From: Carole Paterson [REDACTED]
Sent: 06 January 2021 18:58
To: Planning <Planning@arun.gov.uk>
Subject: Ref R/234/20/HH

I object to this planning application on the grounds of the side windows which are a complete intrusion to my privacy.

Owner of 121 Old Manor Road.

119 Old Manor Road
Part Proposed Side Elevation (North)
Scale: 1:50
April 2020
Drawing 6

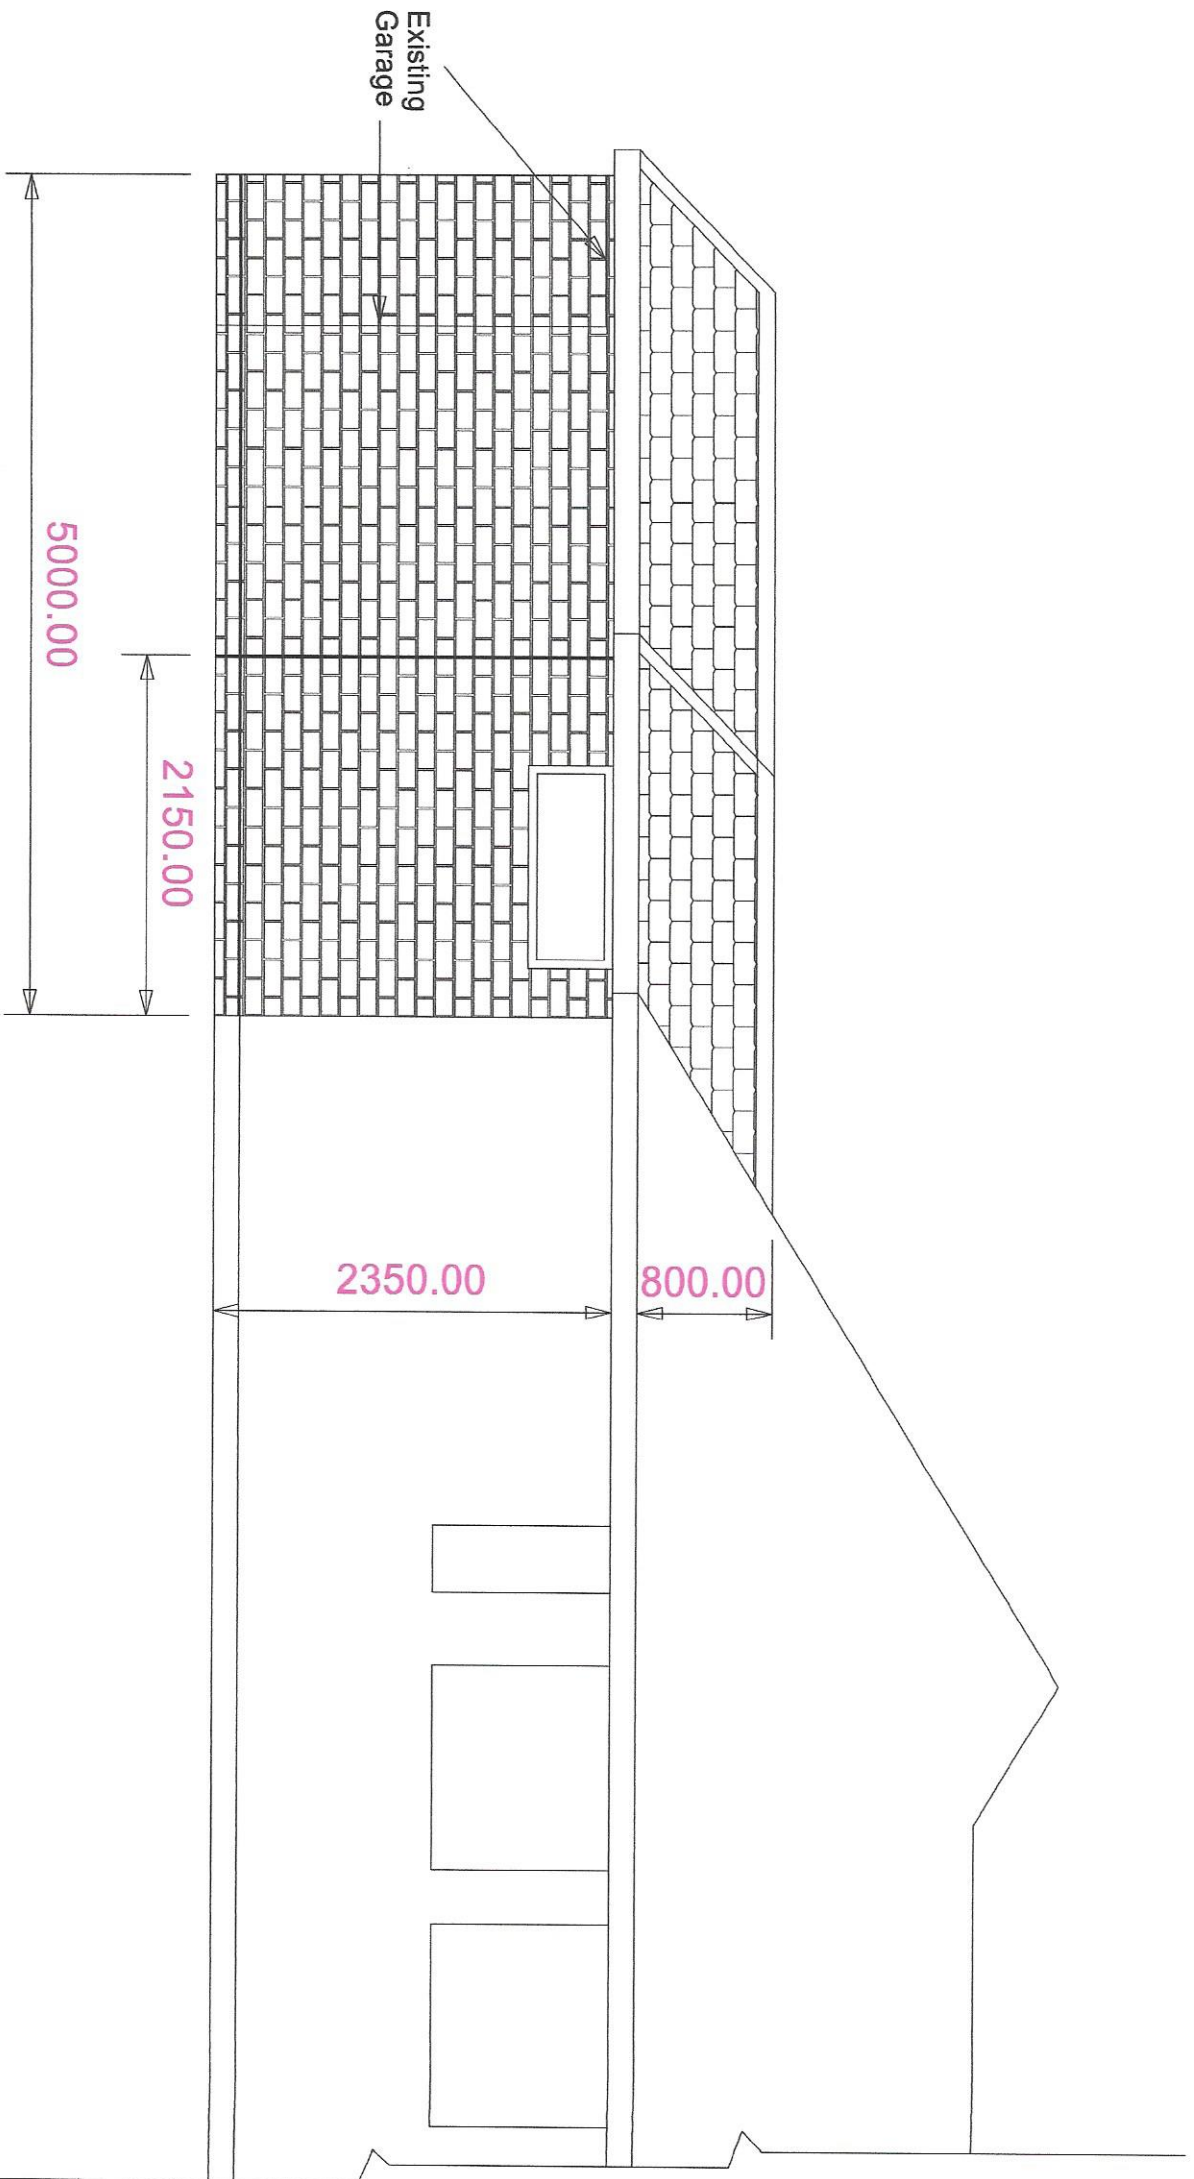
My party wall surveyor gave me a plan showing the windows as being non-opening, but I have seen them both open. One of the windows that opens is very near to my bedroom window and both windows overlook the patio.
